Morecambe Offshore Windfarm: Generation Assets Examination Documents

The Applicant's Response to ExA's Written Questions 3

Document Reference: 9.61

LEGEND

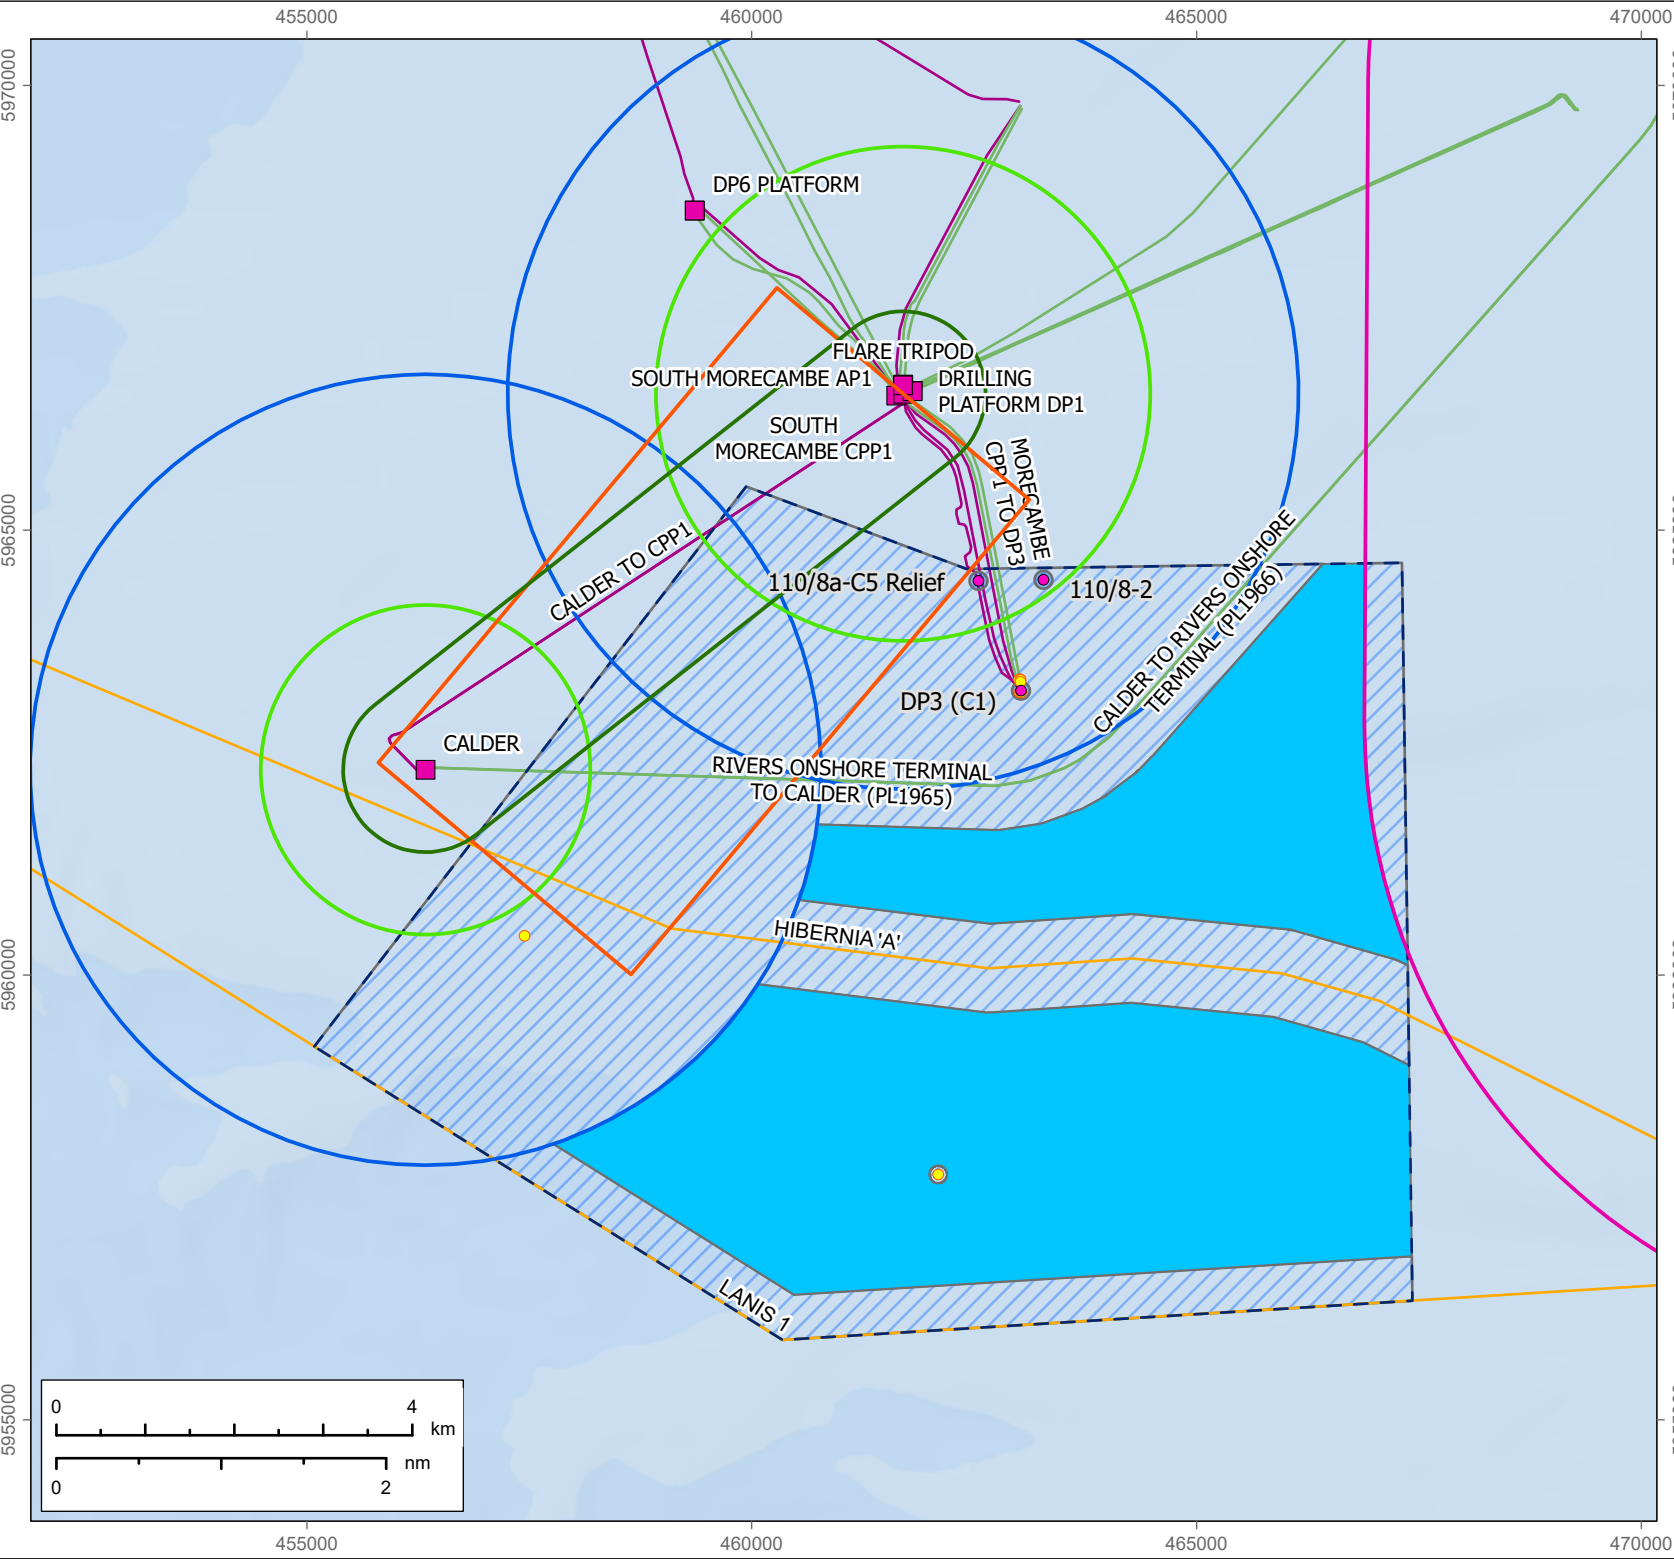
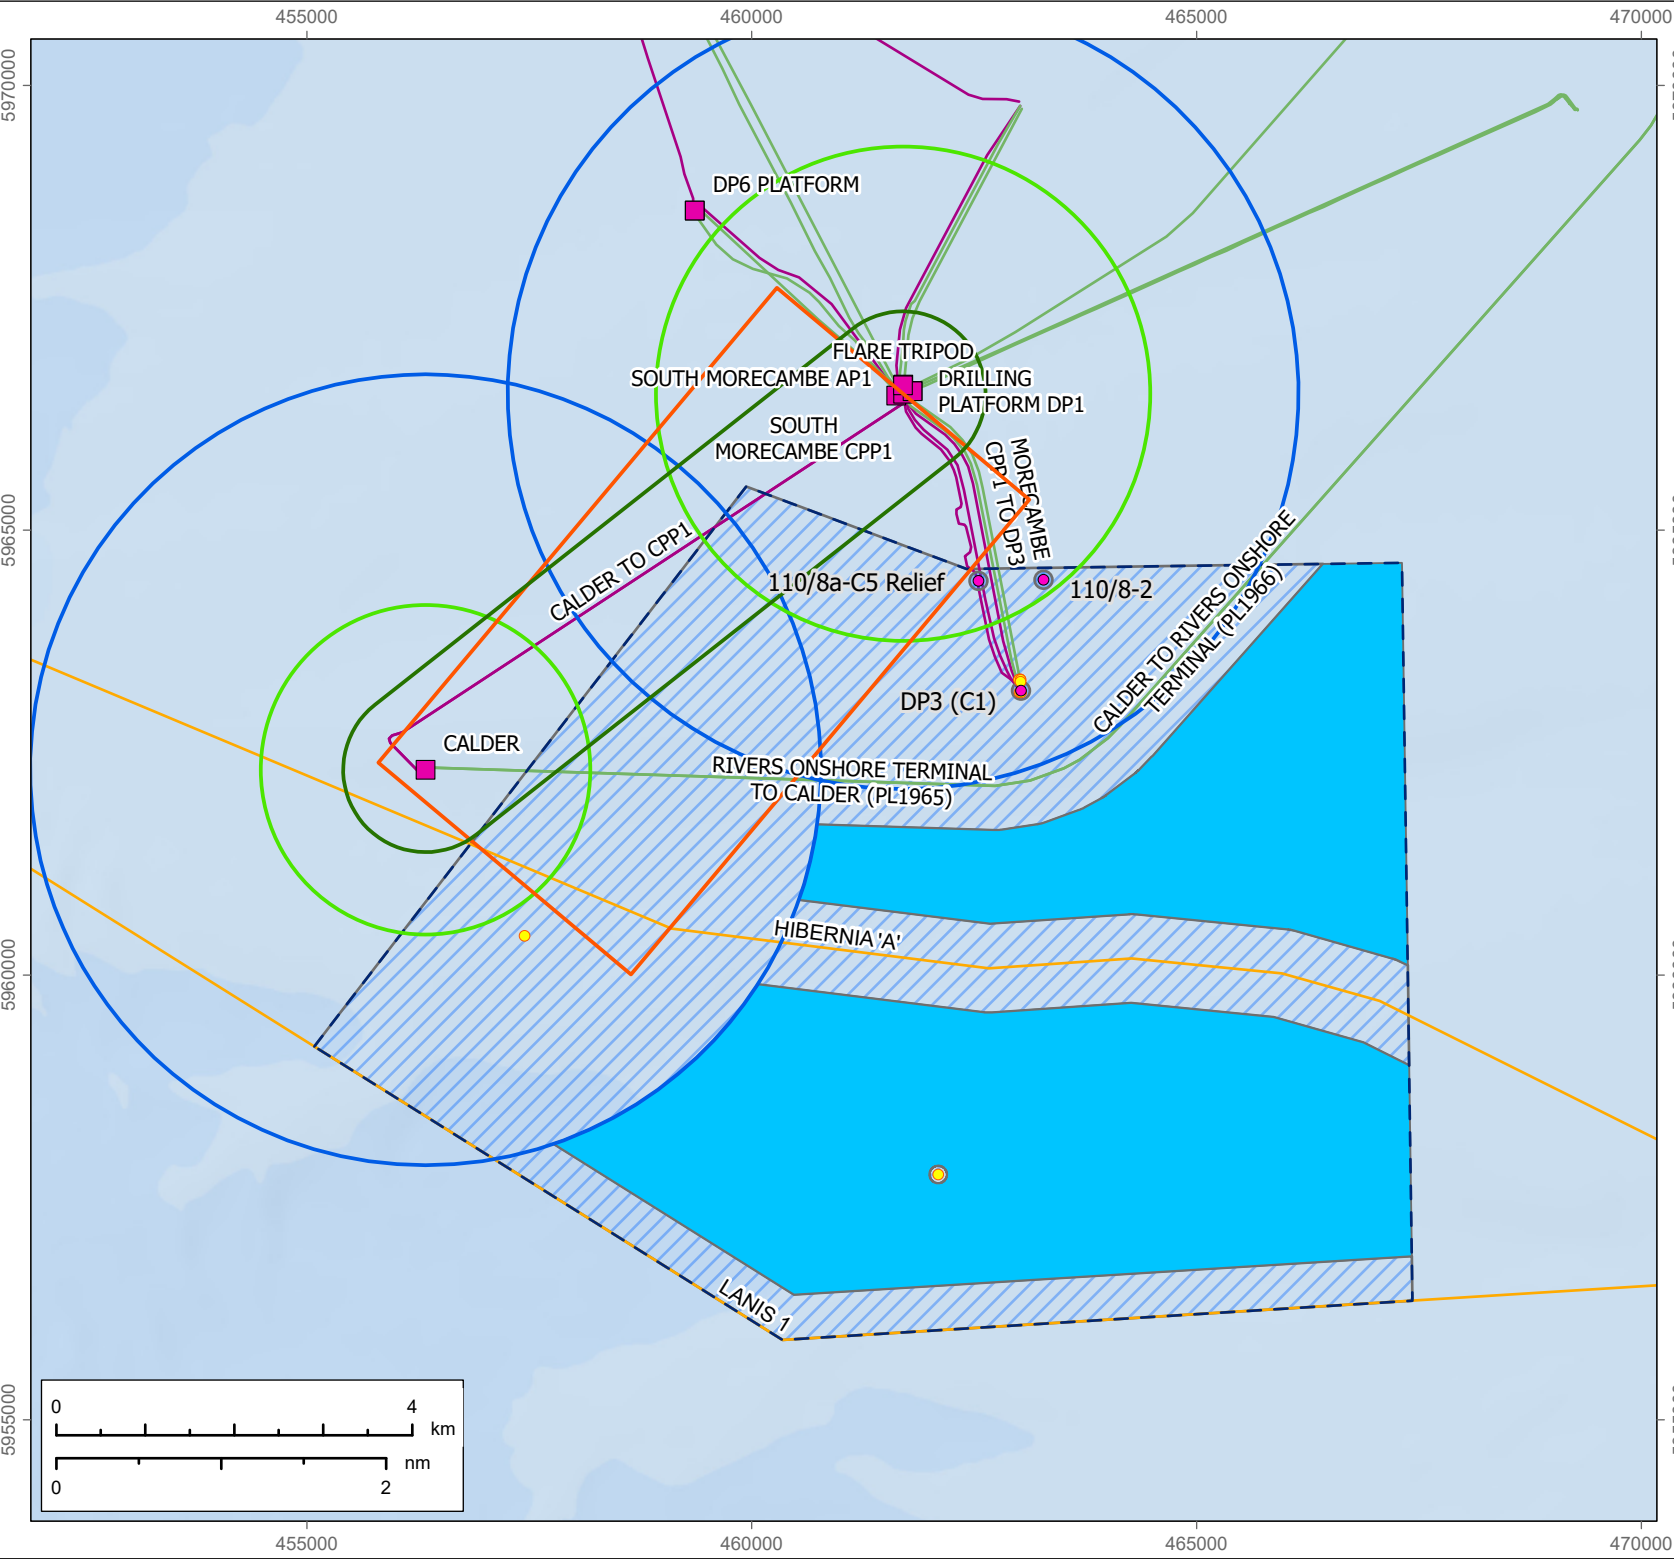
Ref.	Question to:	Question	Applicant's Response										
		<p>b) in Spirit Energy's response to ExQ2CAR5 at D5 [REP5-090] it advises a buffer distance of 1.9nm is the minimum acceptable requirement for safe landing and take-off in daytime VMC and for night VMC this distance would be 2.4nm. In light of this could the applicant provide plans for each alternative SPA buffer scenario in (a) plus each of the increased buffer scenarios from the Calder and CCP1 platforms as set out in the following table.</p>

<p>c) any additional comments or further information the applicant wishes to provide on the implications of each of the above scenarios (noting the applicant's previous response [REP5-070], EXQ2HRA3 and 2HRA6].</p> <p>The ExA is seeking a complete set of alternative scenarios shown on plans, so that, whatever the SoS may determine, if they felt it was appropriate they could include the relevant plan within any final DCO without having to revert to the applicant for that plan. Each should therefore have a different drawing number.</p>	<u>CPP1 WTG and OSP Aviation Buffer</u>	<u>Calder WTG and OSP Buffer</u>	1.9nm	1.9nm	2.4nm	1.9nm	1.9nm	2.4nm	2.4nm	2.4nm	
<u>CPP1 WTG and OSP Aviation Buffer</u>	<u>Calder WTG and OSP Buffer</u>												
1.9nm	1.9nm												
2.4nm	1.9nm												
1.9nm	2.4nm												
2.4nm	2.4nm												
3GEN4	The applicant	<p>Design Statement - Cabling</p> <p>Could the applicant please explain why (former) provision DC15 relating to use of the most direct/ efficient cabling</p>	<p>The Applicant removed the former provision DC15 as it considered that this was duplication of DC10. The Applicant has updated the Design Statement_Rev 04</p>
